# **KIRKLEES METROPOLITAN COUNCIL INVESTMENT & REGENERATION SERVICE**

| Reference No:         | <b>2023/62/91426/E</b>                                                                                                                                     |
| Site Address:         | 5, Wells Mount, Upper Cumberworth, Huddersfield, HD8 8XQ                                                                                                   |
| Description:          | Demolition of existing conservatory and erection of single storey rear extension and first floor side extension with partial conversion of existing garage |

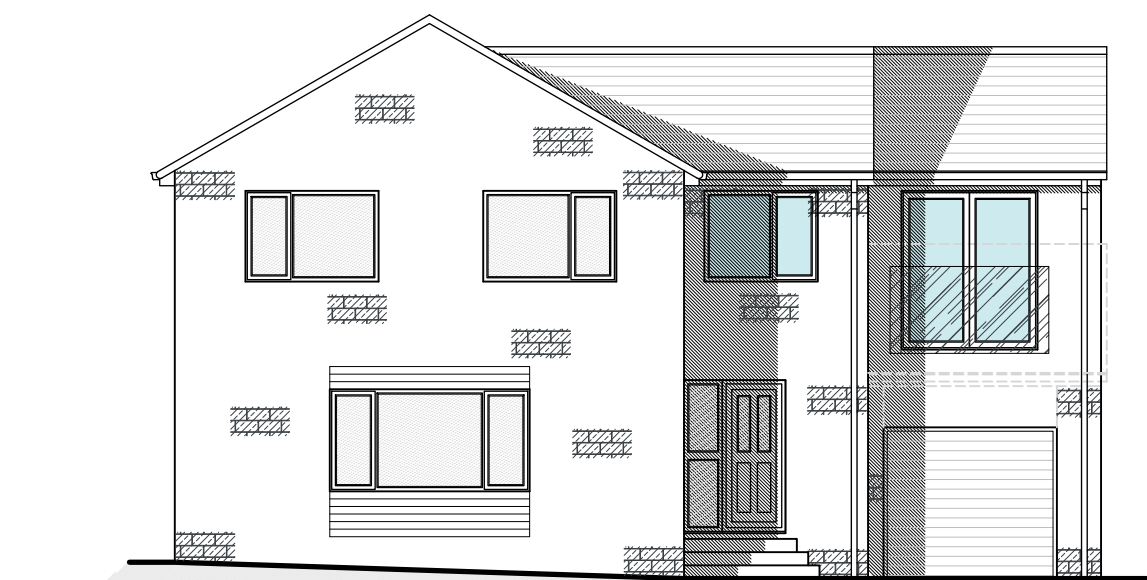
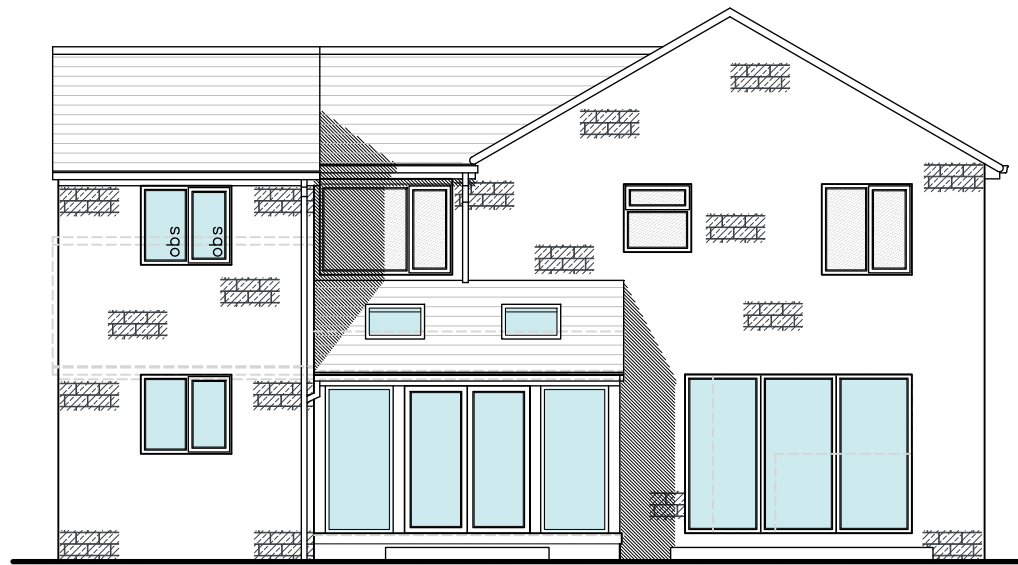
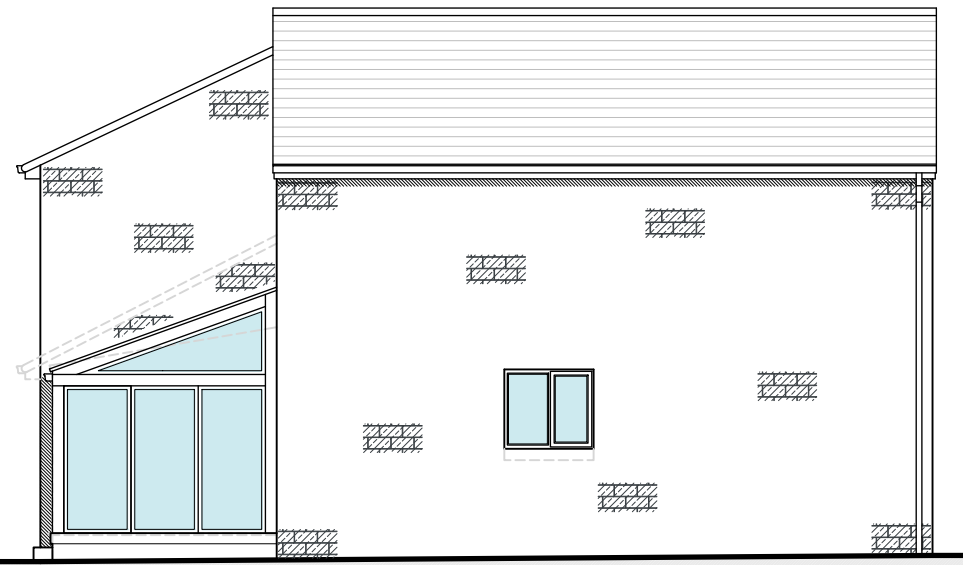
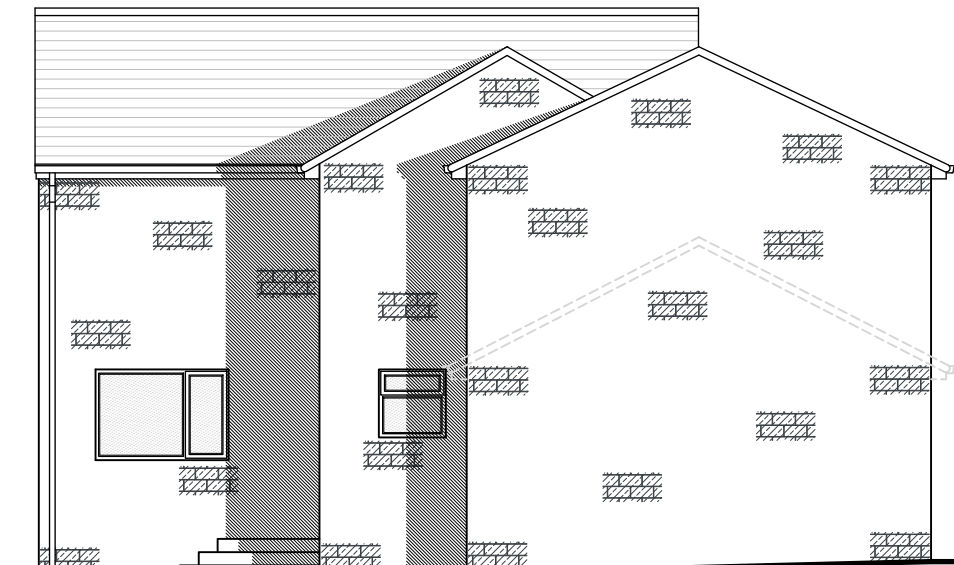
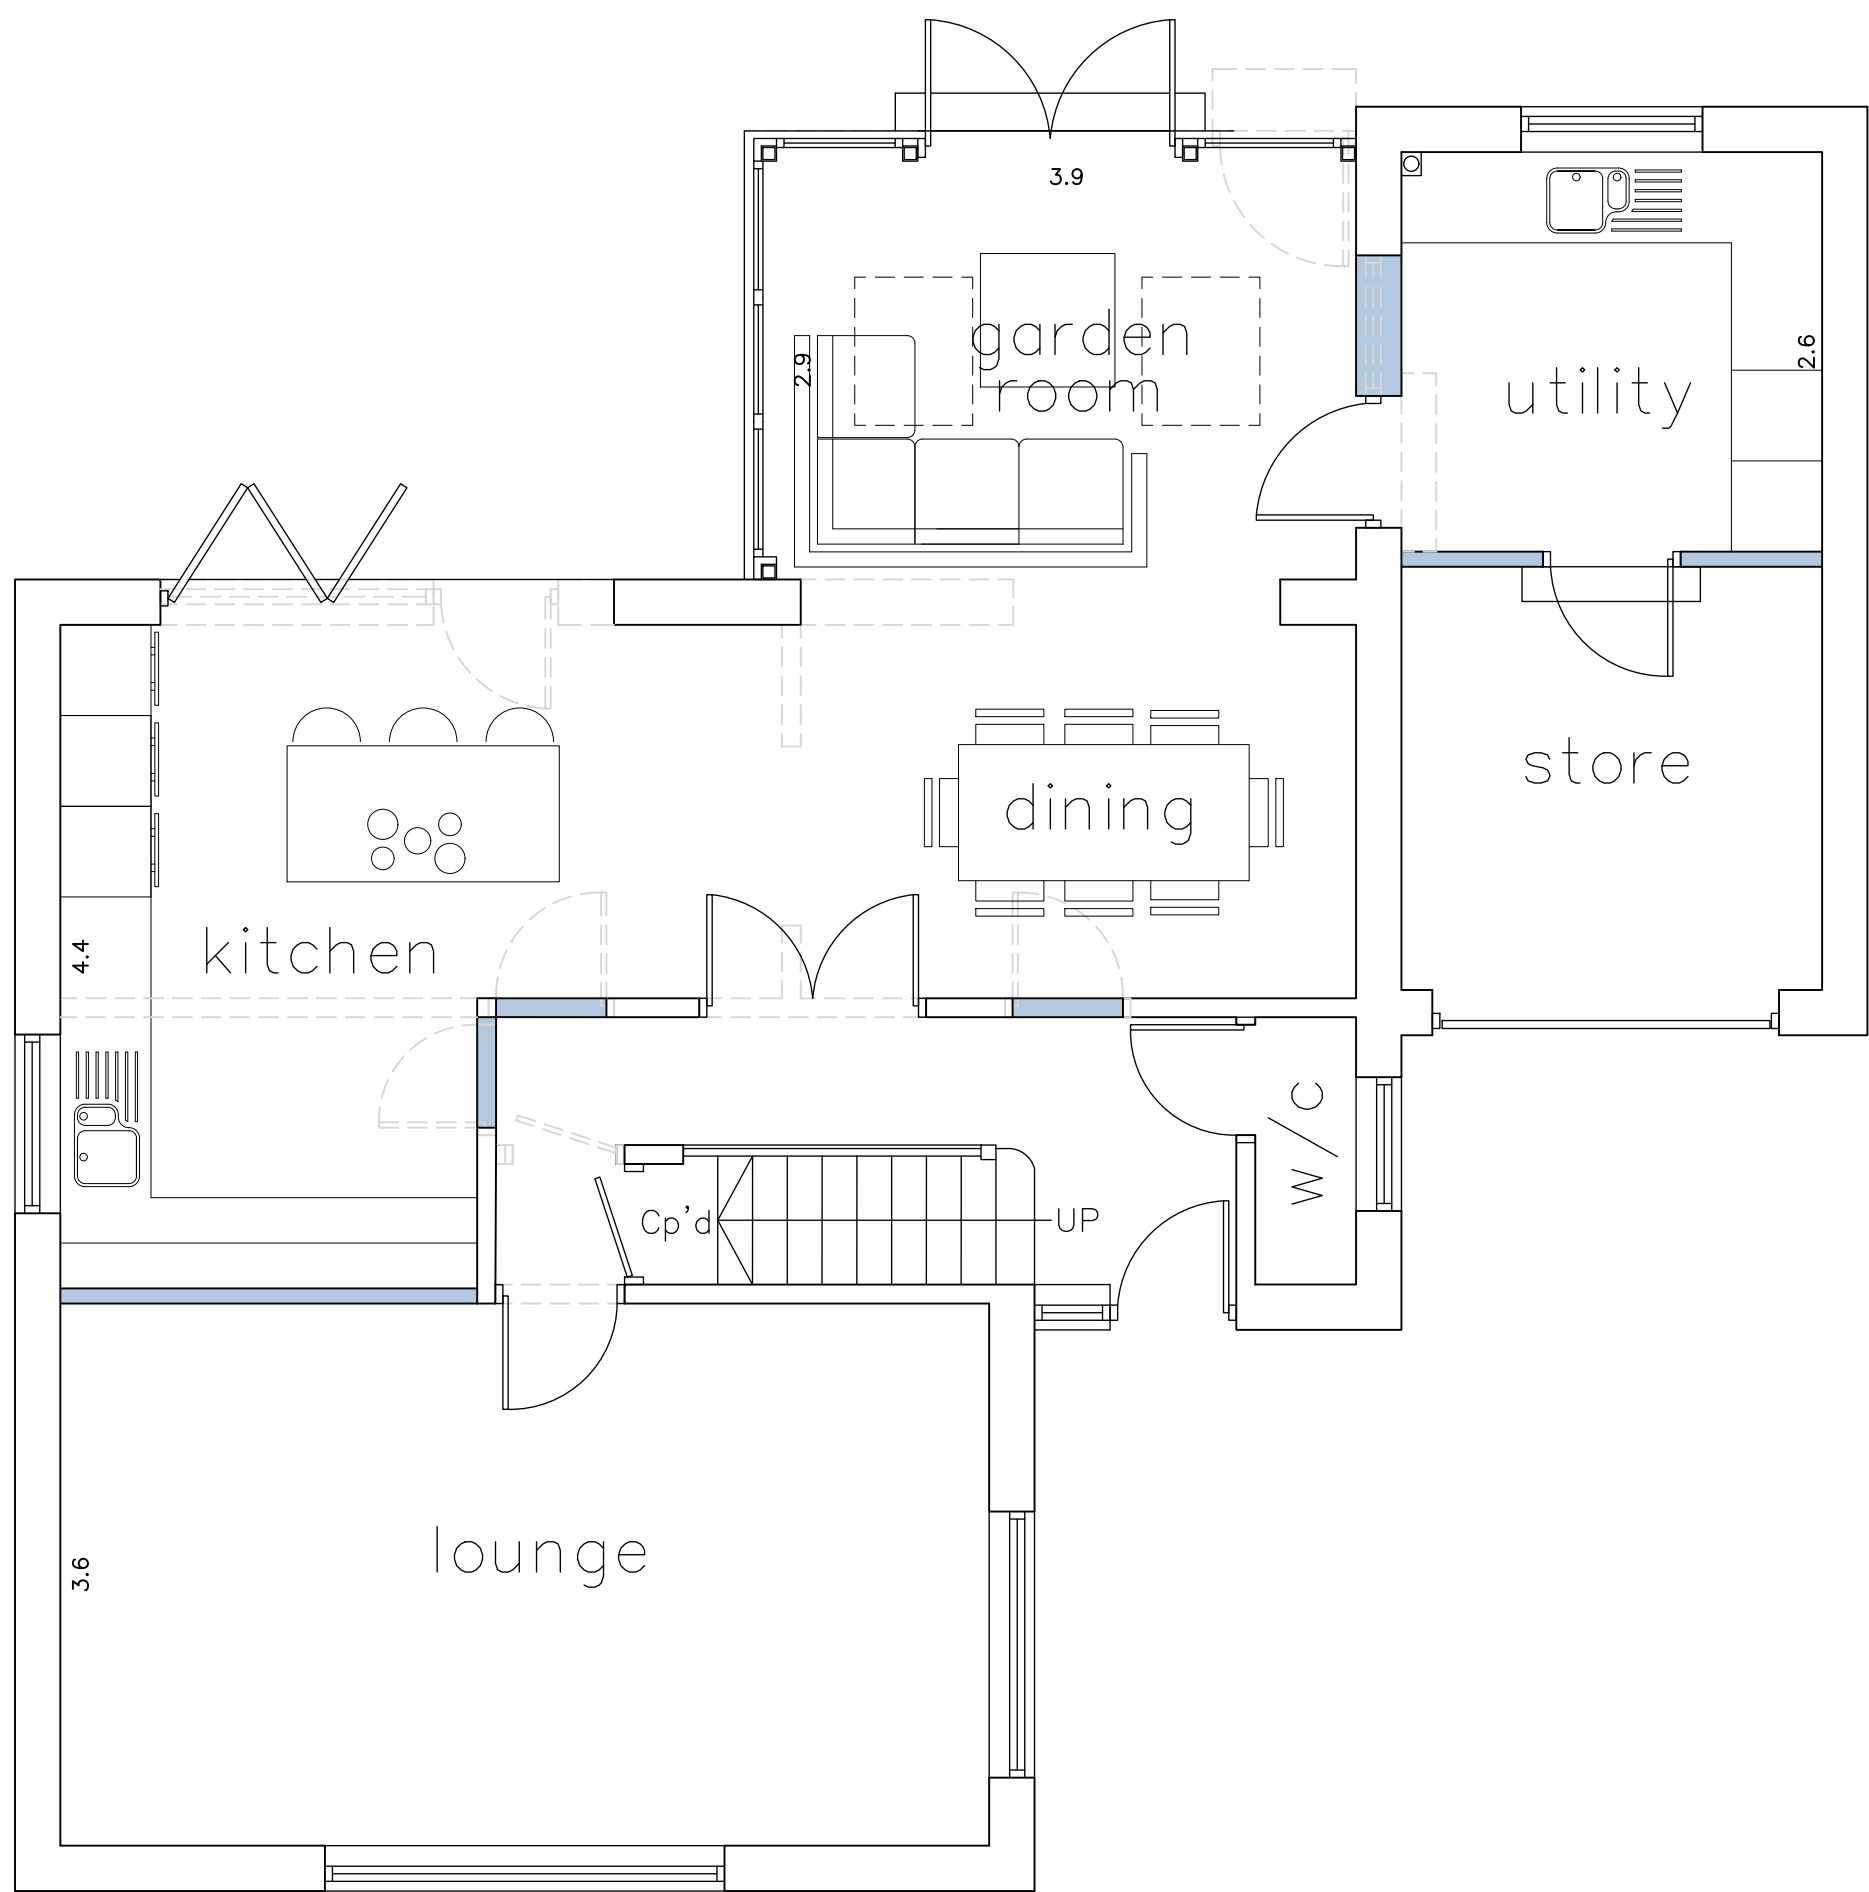
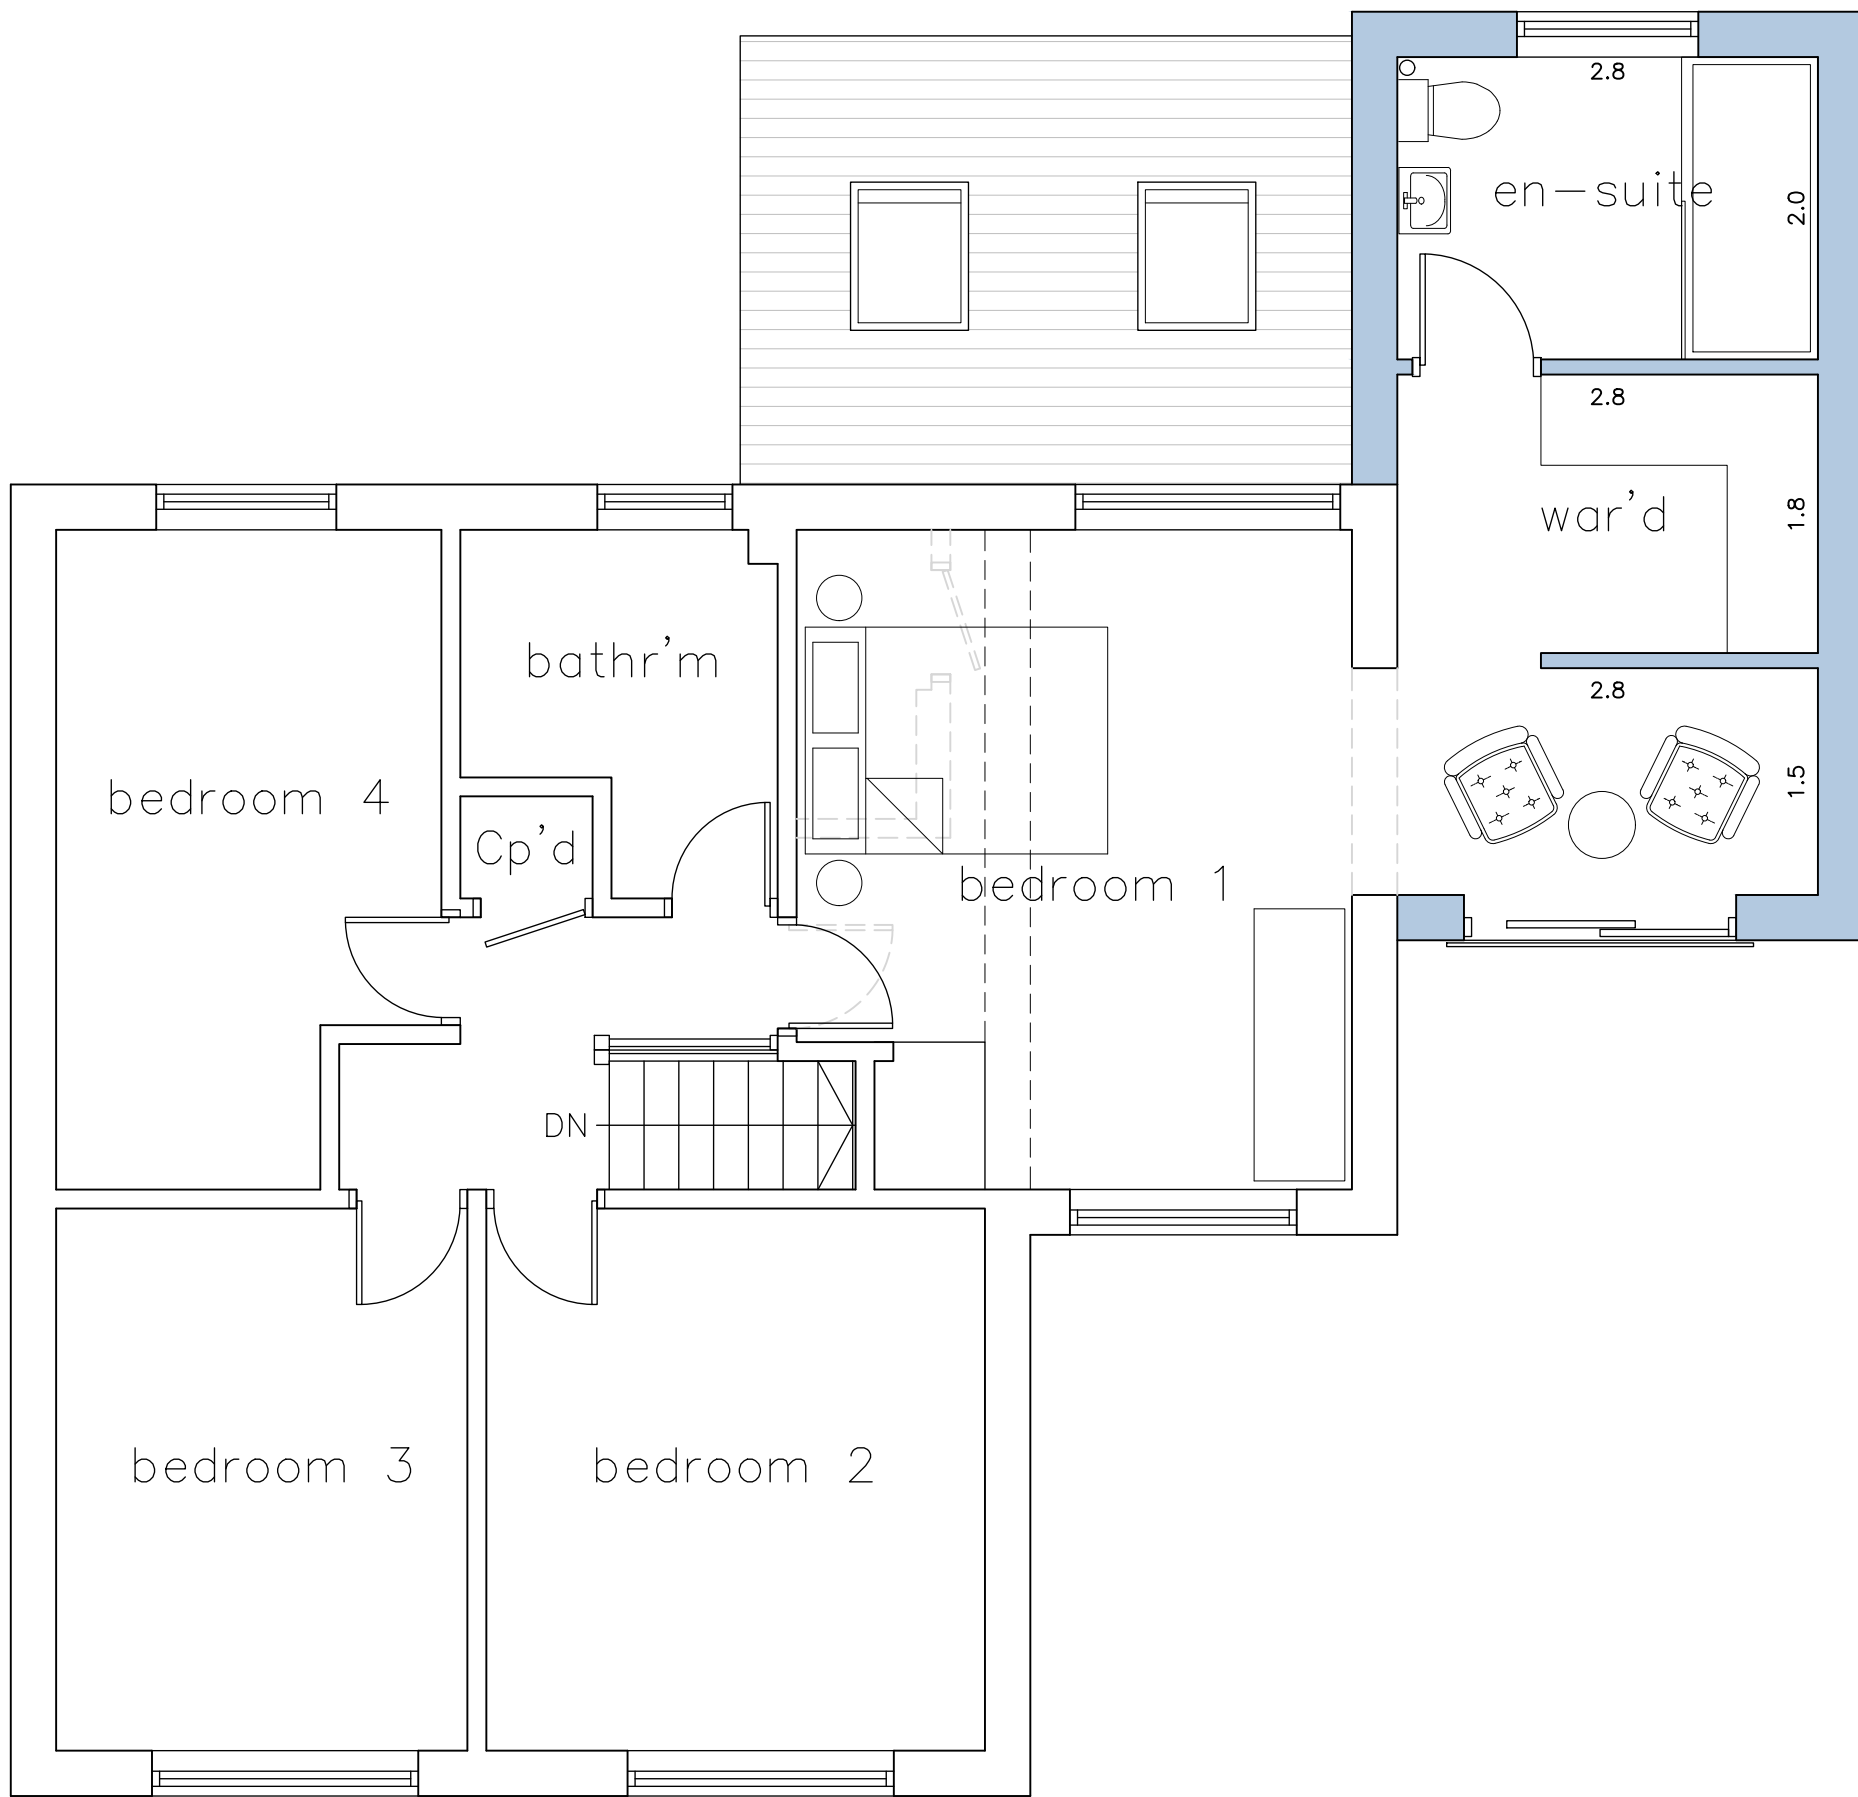
Overshadowing/loss of light: The proposal would extend 8.5m beyond the rear elevation of no.7 and be situated to the south of the dwelling. It is considered that the depth of the proposal coupled with its close proximity, to the neighbouring boundary, would create an unacceptable level of overshadowing for the immediate private amenity space of no.7

Overbearing: As previously highlighted, the alterations to the first floor would extend 8.5m beyond the rear elevation of no.7. It is considered that the proposal would introduce a blank two storey structure closer to the immediate private amenity space of no.7 and a depth of 8.5m. It is considered that this would result in an unacceptable overbearing impact to the occupiers of no.7.

Therefore, it is considered that, the first floor side extension by reason of its scale, proximity to a shared boundary and orientation would result in an unacceptable level of overshadowing/loss of light and overbearing to the private amenity space of no.7 Wells Mount.

Due to the scale, mass and location of the proposal, the extension would create an unacceptable overshadowing and overbearing relationship to the occupiers of no.7 Wells Mount and their private amenity space. The proposal would fail to meet Kirklees Local Plan Policy LP24 in terms of minimising the impact to the residential amenity of neighbouring occupiers and the criteria of the House Extension SPD, particularly KDP 2 & 6 in terms of impact to neighbouring residents and preventing an overbearing impact.
